Our reference: P-564673-G8R1
Contact: Sandra Fagan
Telephone: 02 4732 7992

16 October 2023

**Penrith Council comments on Modification Report- SSD-10448-Mod-4
– Modification Application to Aspect Industrial Estate at 804-882
Mamre Road, Kemps Creek, NSW, 2178**

Figure 5: Stage 1 Development, Phase 1 Stormwater Management Plan

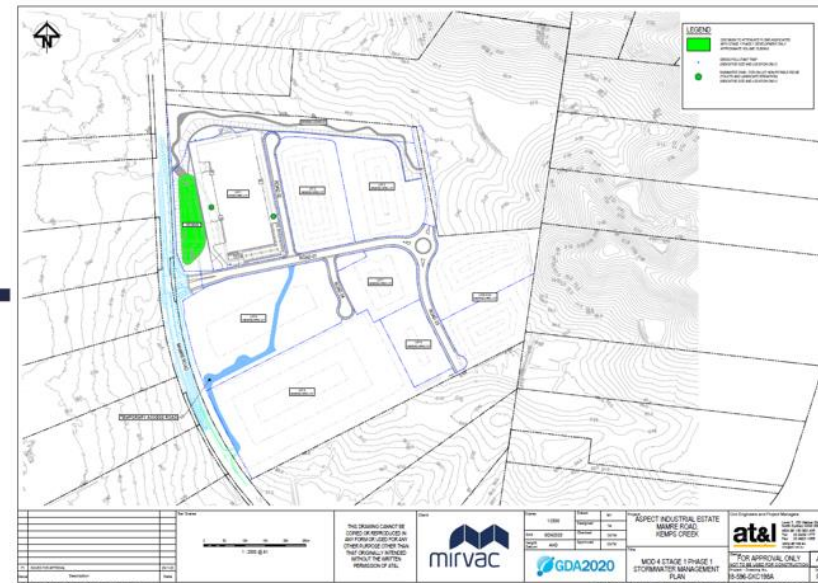
It is also noted that no updated engineering plans were submitted in support of the modification and the proposed conventional biorientation system has now been proposed in place of the previously approved Filterra basin. Further there are no plans to support the assumptions around the MUSIC modelling for the EEP land.

Figure 5A: Stage 1 Development, Phase 2 Stormwater Management Plan

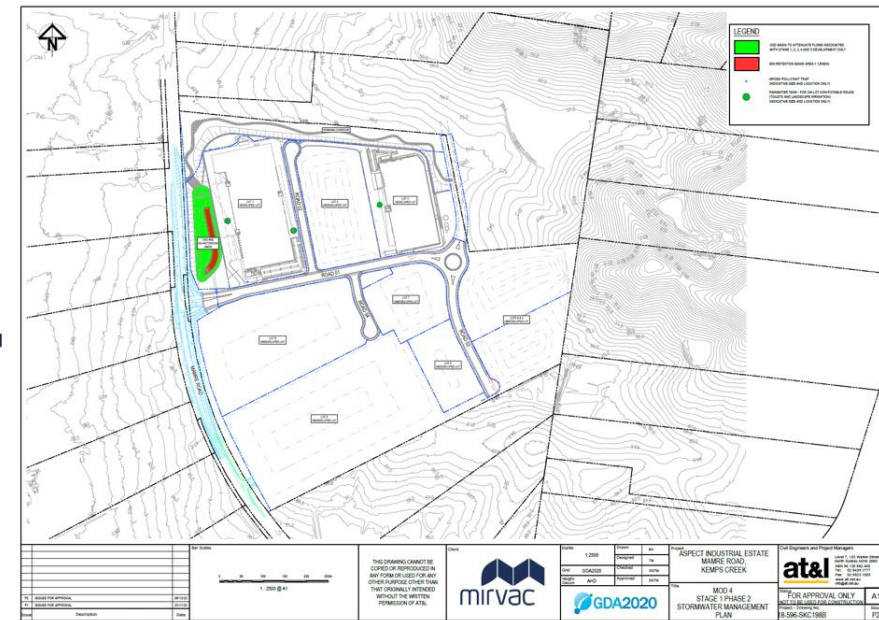
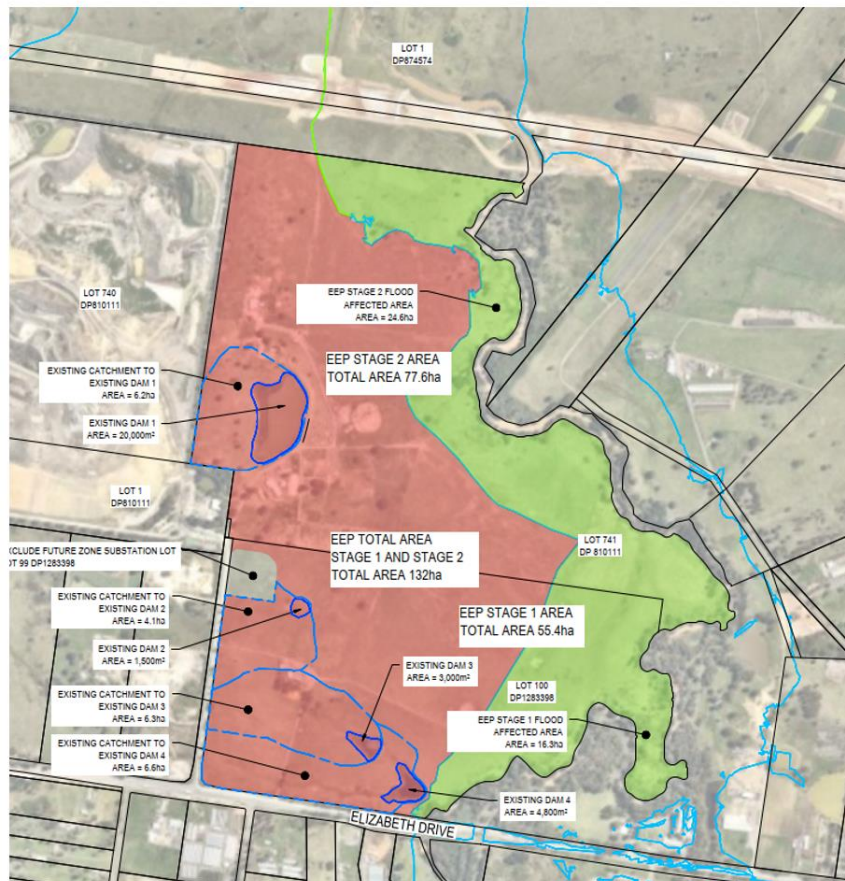
A review of the stormwater strategy indicates that in addition to providing stormwater measures in the form of GPTs and rainwater tanks on AIE on a staged basis for the future buildings, the proposed modification also seeks to incorporate 132Ha of undeveloped land at Mirvac's Elizabeth Enterprise Precinct at 1669-1723 Elizabeth Drive, Badgerys Creek (Lot 100 DP1283398 & Lot 741 DP810111) (EEP) within the AIE concept approval.

From a review of the information provided in support of the application, it is not clear how the proposed approach is fully compliant with the intent of the Technical guidance for achieving Wianamatta-South Creek stormwater management targets. The guideline includes case studies for the interim arrangements for compliance with the absence of the regional scheme. This approach appears to be a departure from the guidelines.
